18 August 2017

Planning Services
Attention: Director - Transport Assessments
Department of Planning and Environment
GPO Box 39
SYDNEY NSW 2001

RE: STATE SIGNIFICANT INFRASTRUCTURE APPLICATION NO. 7475 INLAND RAIL - PARKES TO NARROMINE

**Figure 6.1** Parkes north west connection options

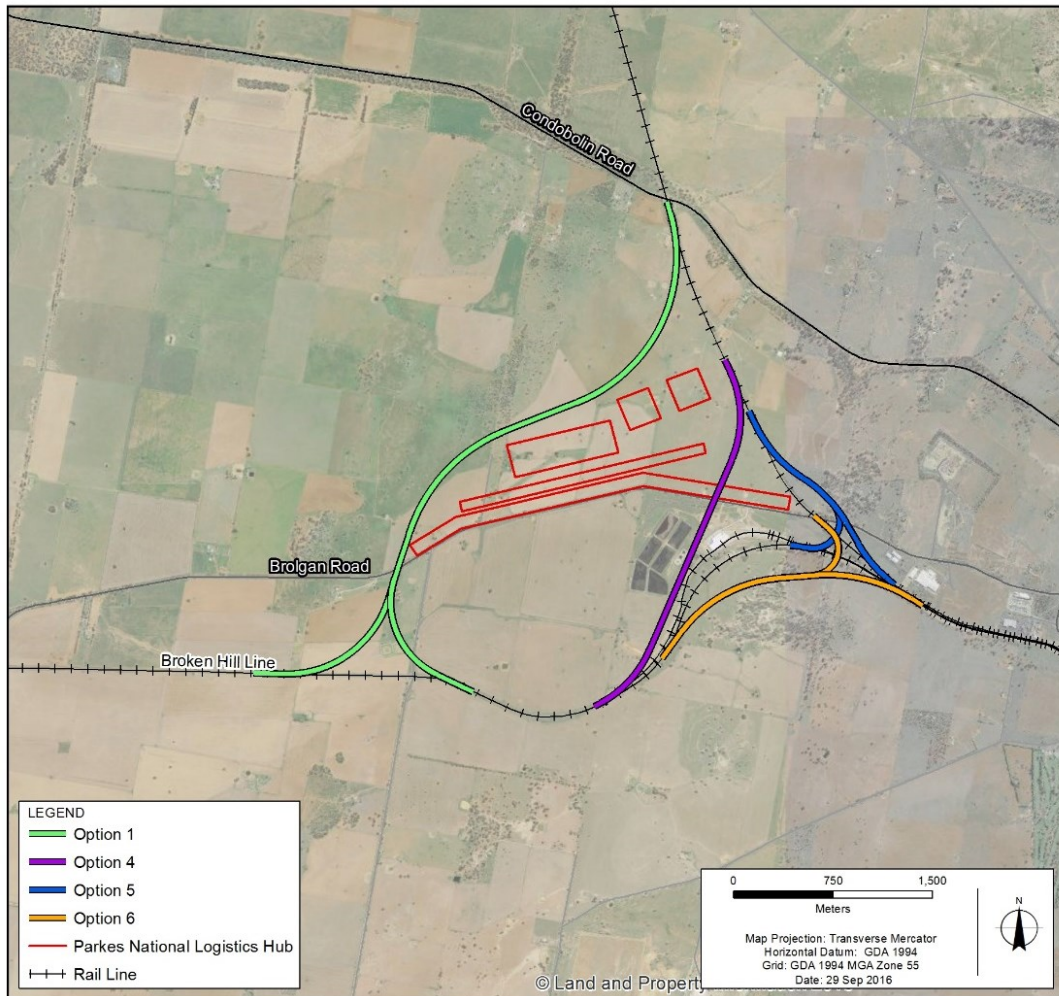
Council welcomes the inclusion of the Parkes North West Connection and Brolgan Road Overbridge as part of the Inland Rail project and supports the proposal that construction will be undertaken in parallel with stage one and two along the existing rail corridor.

Council notes the intention to modify access along Coopers Road, suggesting that Coopers Road could be closed to through traffic. While current traffic levels on Coopers Road are low, it is foreseeable that the road would become more utilised as the Parkes National Logistics Hub develops in the future. Coopers Road provides an important north-south link between Brolgan Road and London Road which will provide heavy vehicle access to the Hub. As detailed design of the Brolgan Road overbridge and Parkes North West Connection is developed, Council would be happy to investigate safe crossing treatments to enable Coopers Road to remain open.

**Figure 6.2** *Brolgan Road overbridge options*

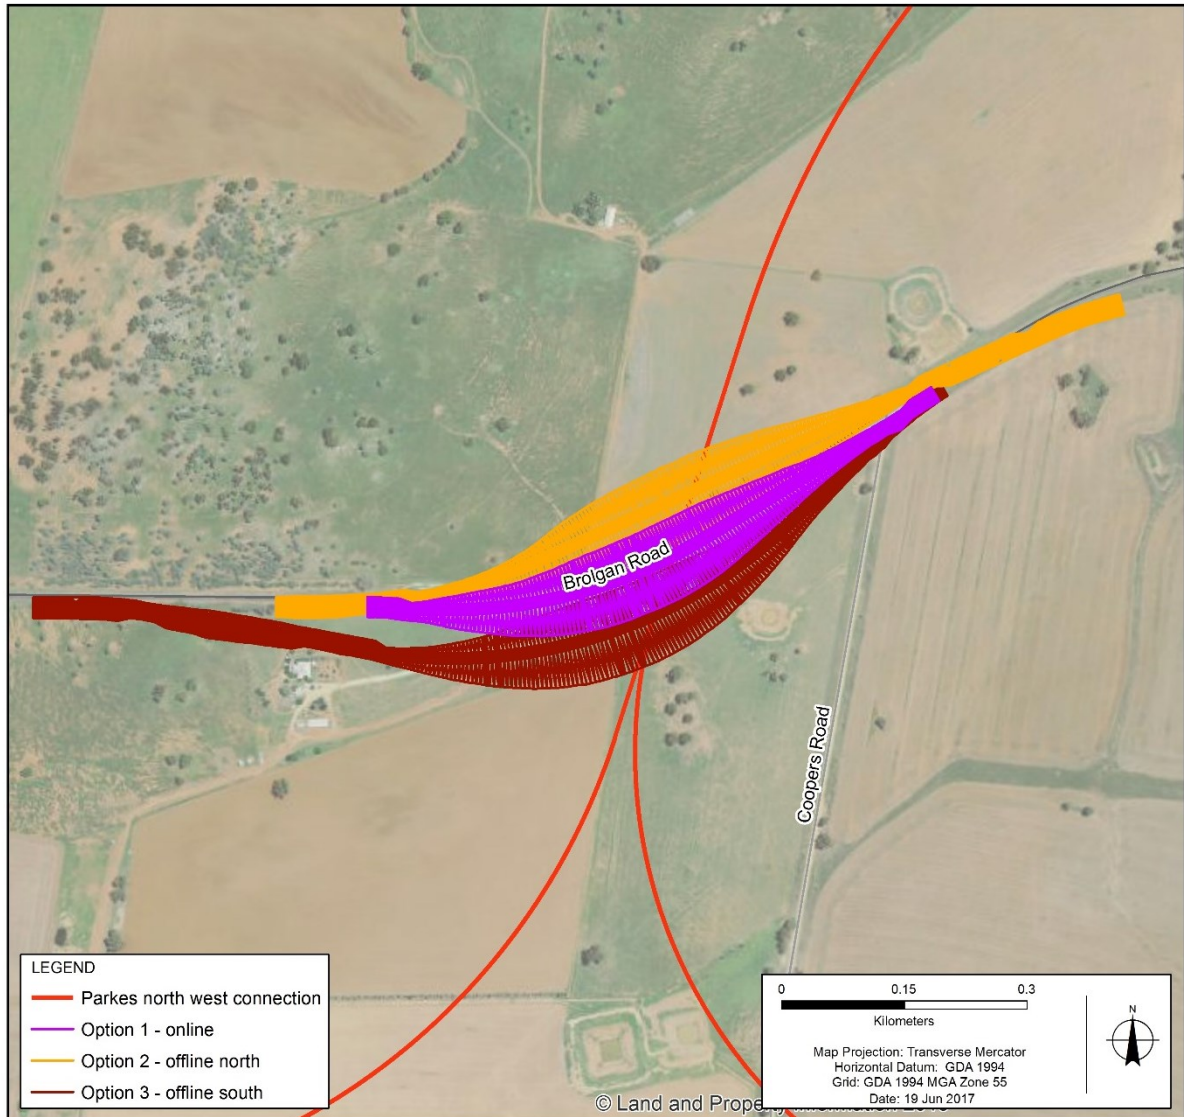
The concept Brolgan Road Overbridge alignment and design appears to satisfy Council's road design standards. Offsetting the alignment as proposed would minimize impact on Brolgan road during construction of the bridge and subsequent construction of the rail line.
